**From:** [alan.story@hertfordshire.gov.uk](mailto:alan.story@hertfordshire.gov.uk)  
**To:** [Planning](#)  
**Subject:** Planning application 6/2019/1452/MAJ - 26 Stonehills  
**Date:** 25 September 2019 14:31:40

**Response to Planning application from Hertfordshire County Council (T and CP GDP Order 2015)**

**District ref:** 6/2019/1452/MAJ

Change of use for conversion of first and second floors from Retail (A1 Use) to Residential (C3 use) and additional storey for 27 dwellings

Scale 1:200 @ A1	Date MAY 2019
Drawn JT	Checked RC
Drawing Number 7654/P109	Revision -

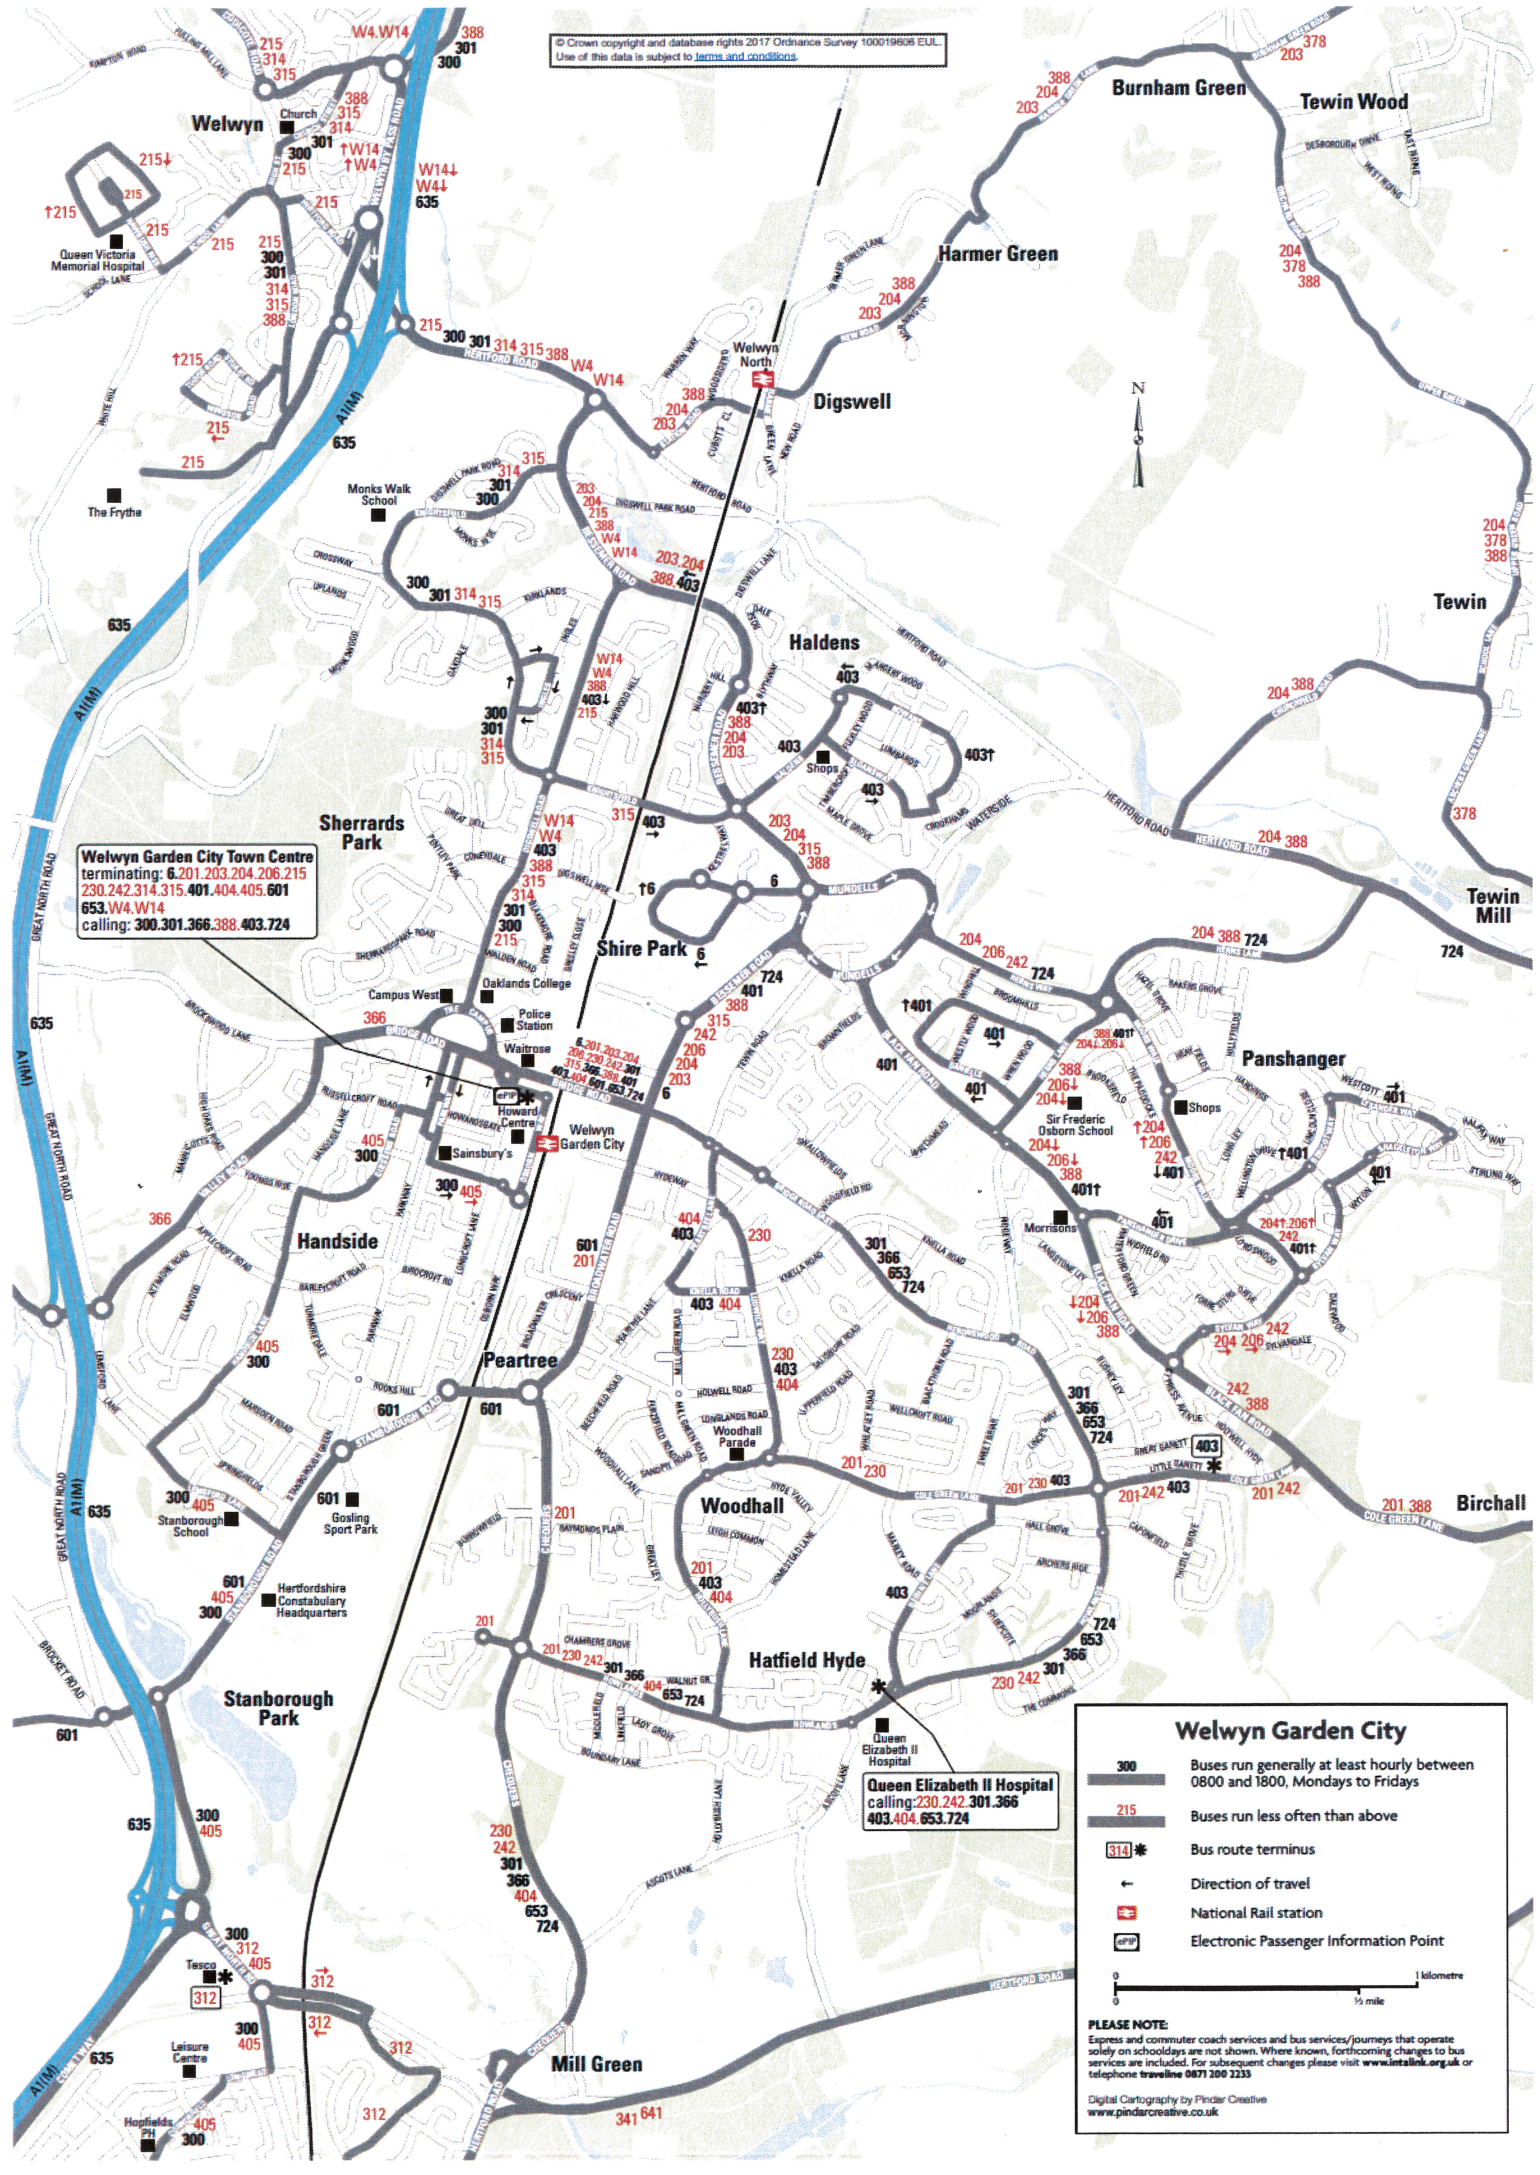
There is some doubt over the position and carry distance of recycling bins. Drawing no 17125/0 (Proposed On-Street Loading) suggests the carry distance from the site to the loading bay on Wigmores North (bin storage on day of collection) is 20m. However, drawing no 7654/P109 (Proposed site Plan) the distance appears to be approx. 50m. From a Highways perspective – the HA would expect that a 25m drag distance between point of storage and point of collection be provided.
